## ASSESSMENT REPORT

### Building R1, Barangaroo South SSD 6513 MOD 3

This report provides an assessment of a section 96(1A) modification application lodged by Lend Lease (Millers Point) Pty Ltd (the Applicant) seeking to modify a State significant development application (SSD 6513) for the construction and use of Building R1 as a pub at Barangaroo South within the City of Sydney local government area. The application seeks approval for design amendments to the ground floor planter boxes, four signage zones and minor ground floor design and layout amendments.

1. SEE CAD MODEL FOR OTHER DIMENSIONS
2. ALL DIMENSIONS IN mm
3. TOLERANCE UNLESS SPECIFIED OTHERWISE
LINEAR: ±0.20
ANGULAR: 0.5

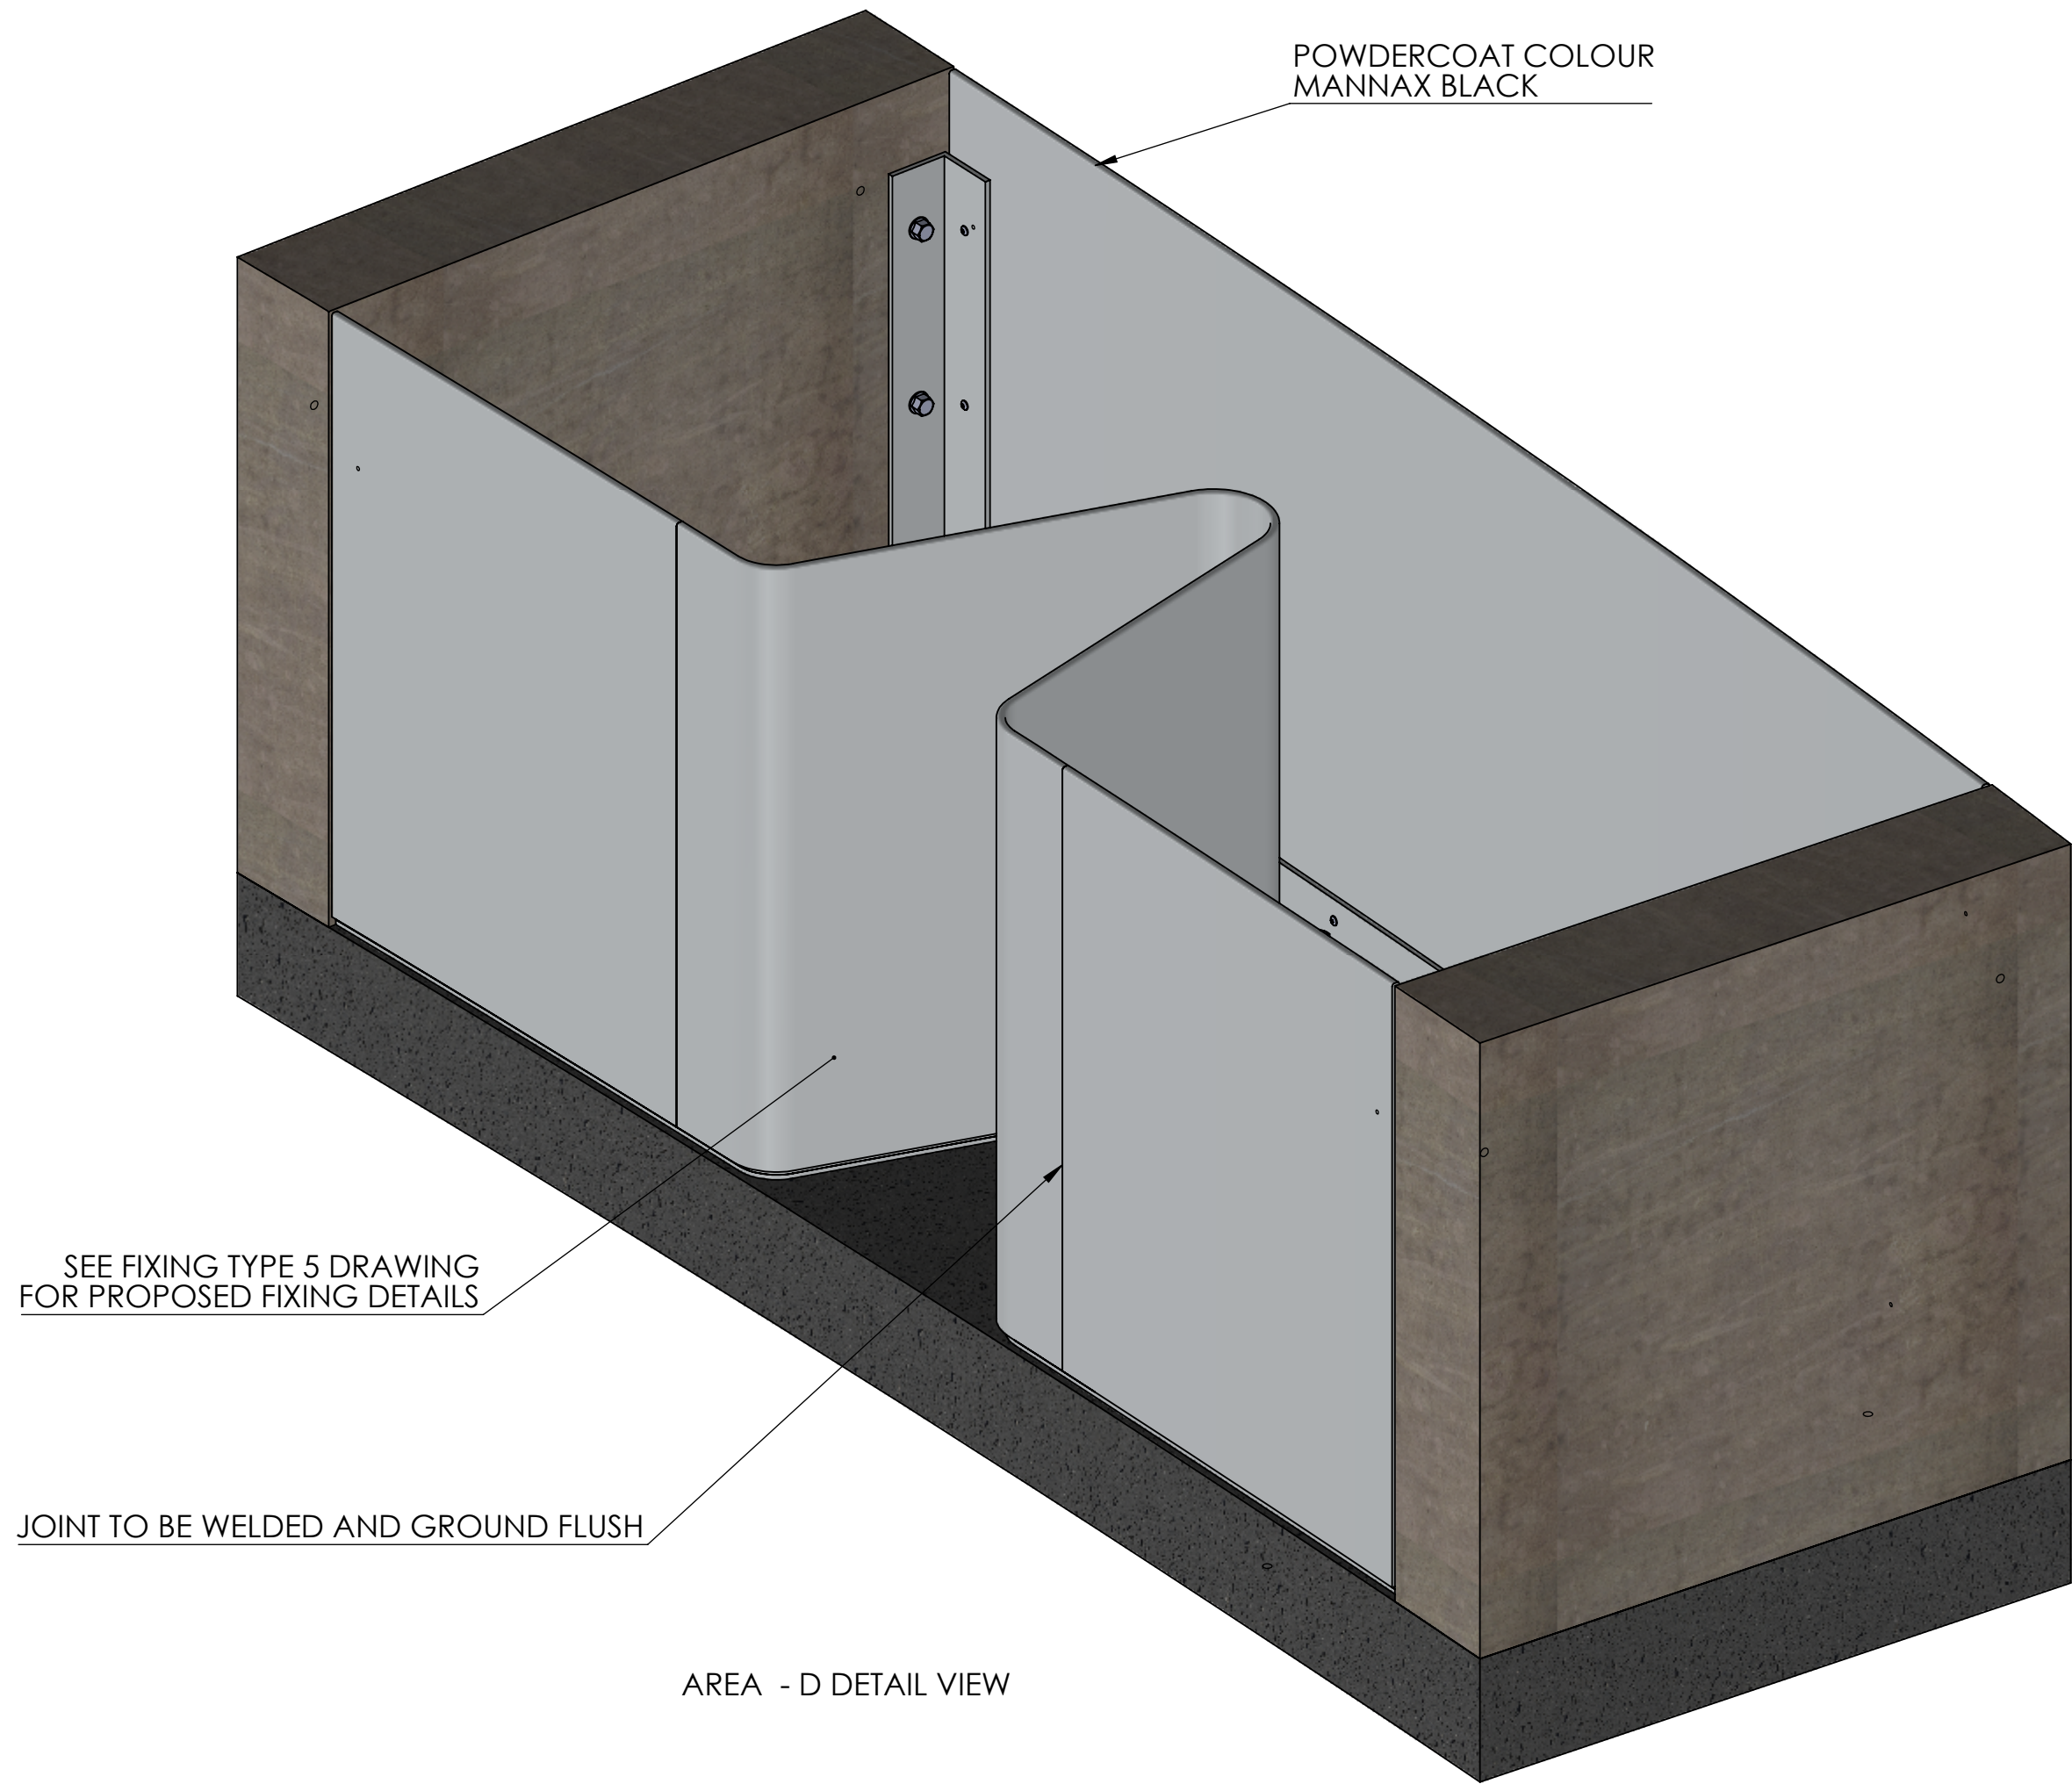
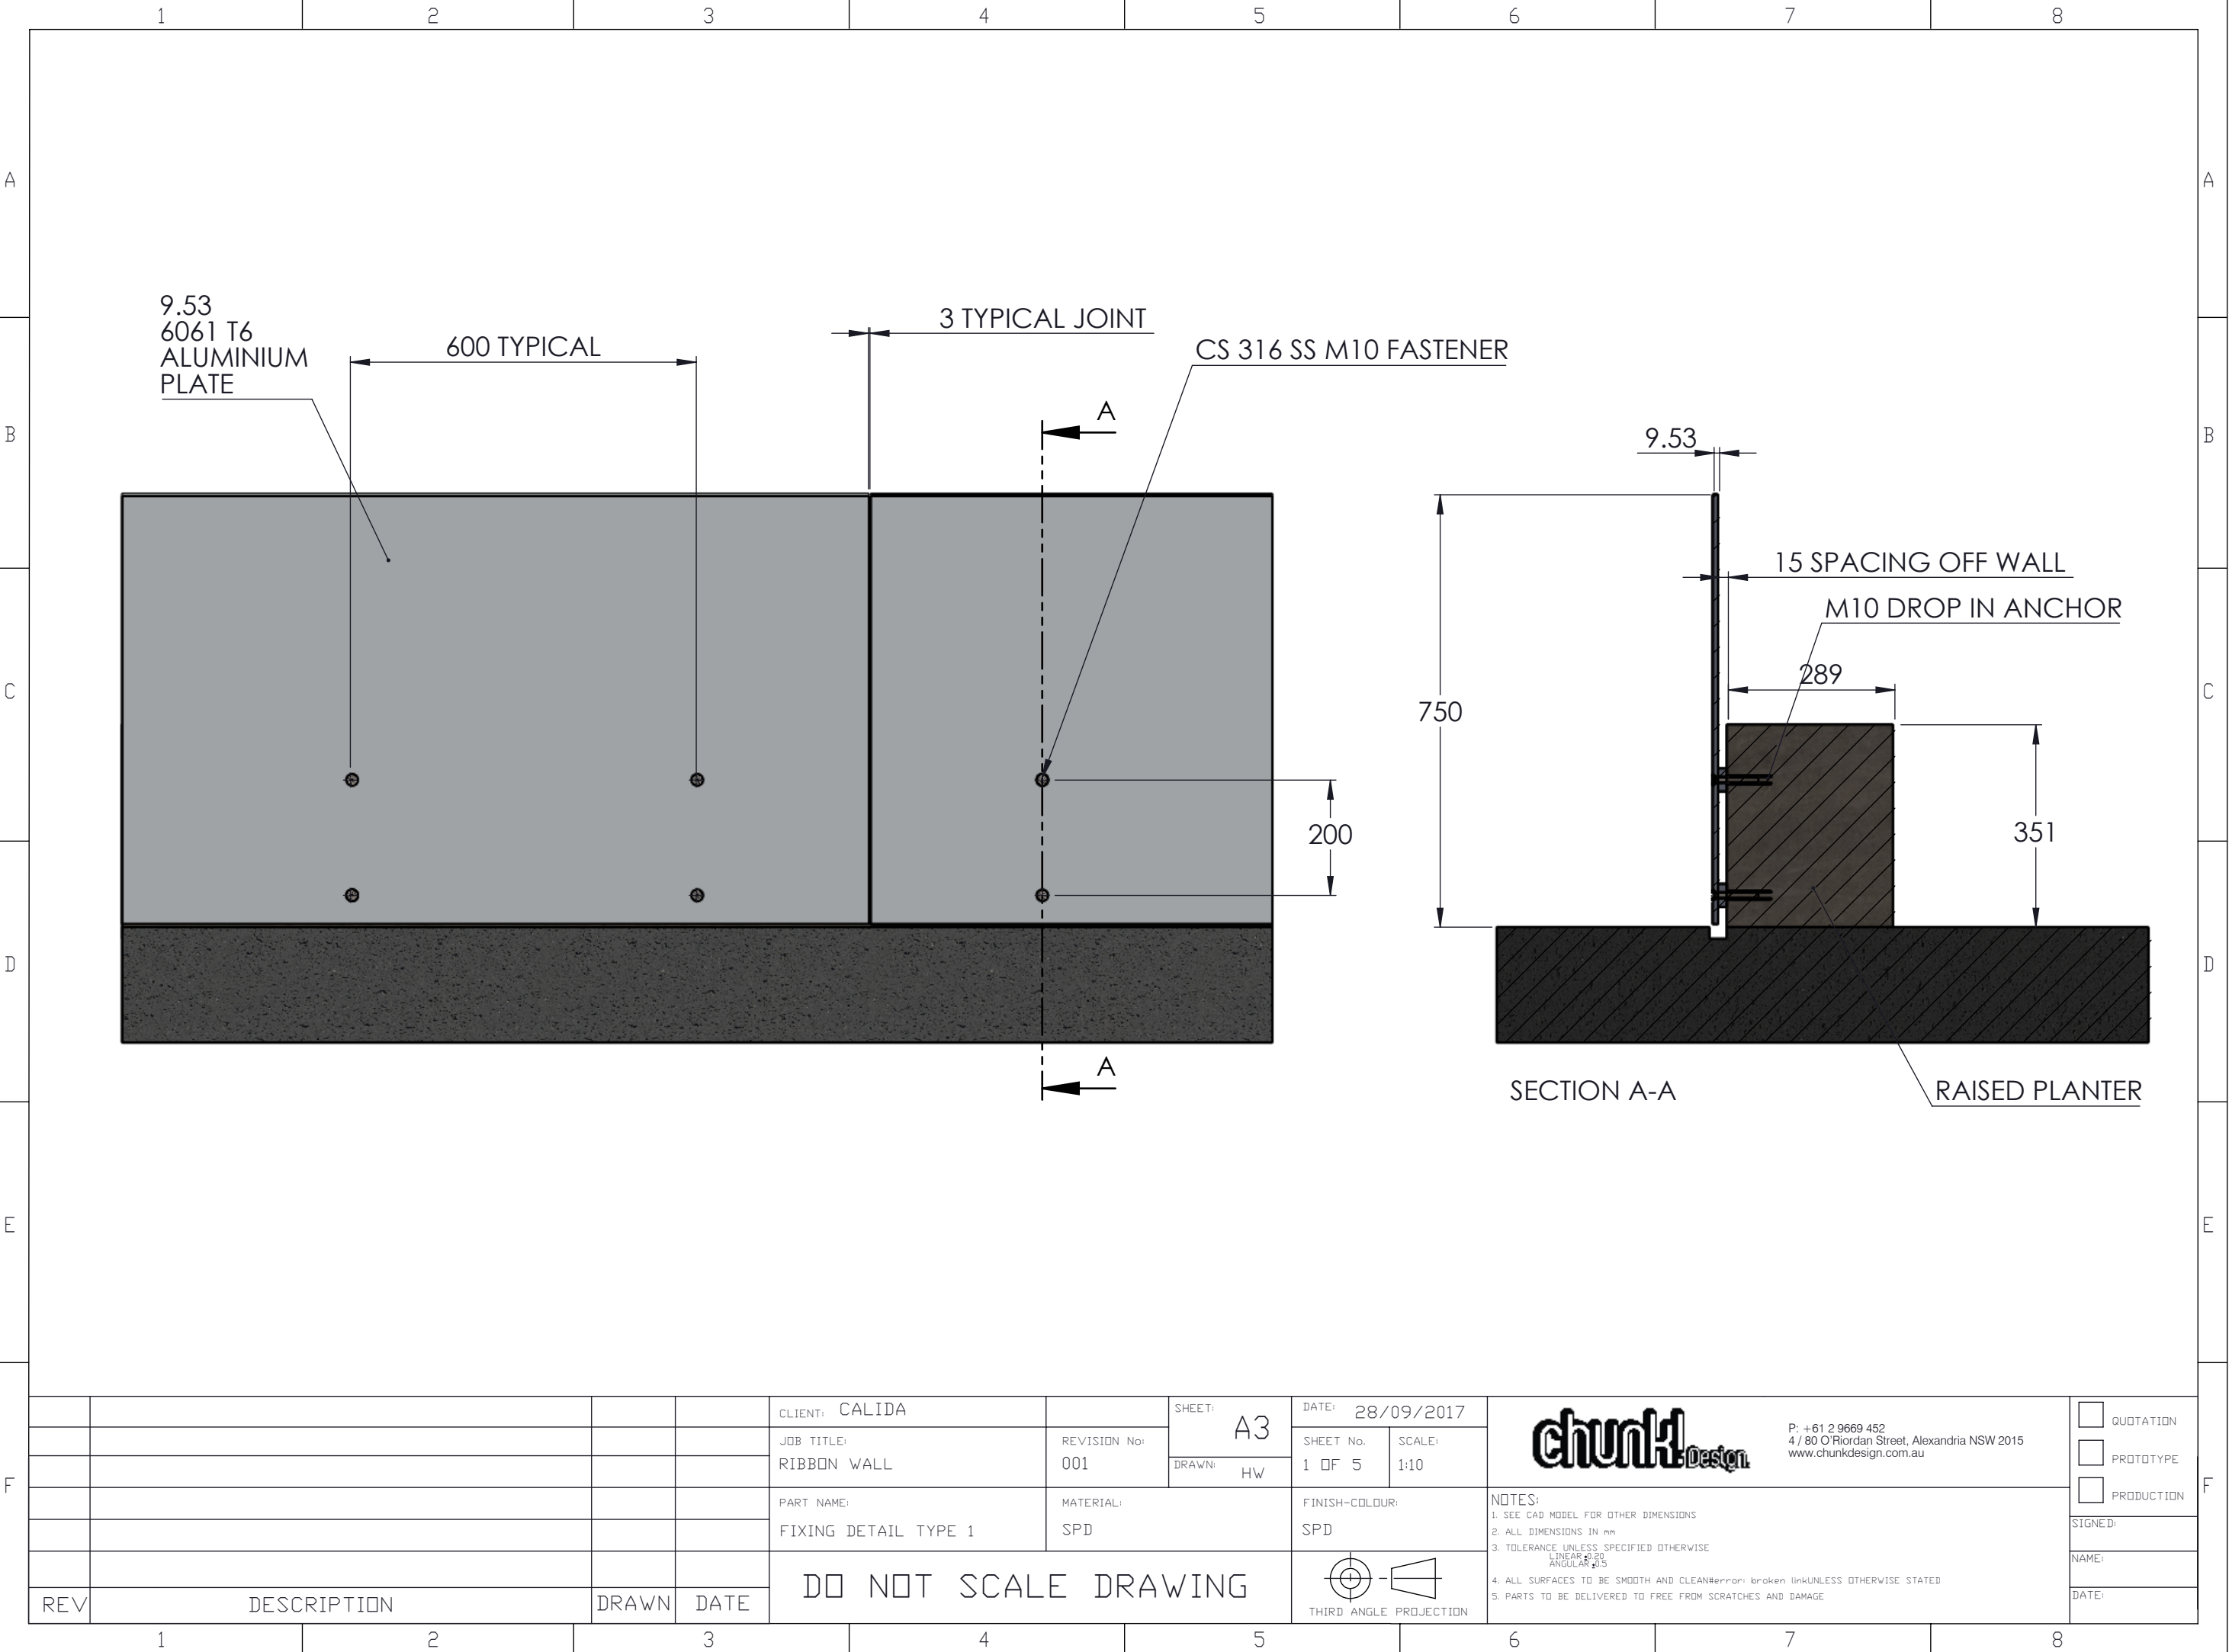
- the need for more detailed plans showing the folded metal planter boxes and how the proposed signage zones integrate with structures
- inadequate consideration of Crime Prevention Through Environmental Design (CPTED) principles
- the proposed new seating zone in the south-eastern corner of the building being isolated from other areas of the building which would limit the ability of staff to properly managed patrons within that space.

Council requested more detailed plans be provided showing the folded metal planter boxes.

In response to Council's concerns, the Applicant provided additional diagrams 'for information' which illustrate the proposed folded metal planter boxes in more detail (**Figure 6**).

The Department has reviewed the information provided and notes the proposed planter boxes have been architecturally treated, integrated into the design of the existing landscaping and appropriately sized to ensure they do not interfere with or detract from the adjoining public domain. The landscaping and materiality (steel) of new planter boxes would be consistent with the approved design.

Given the above, the Department supports the design of the modified planter boxes and is satisfied they would not adversely impact on the surrounding public domain.
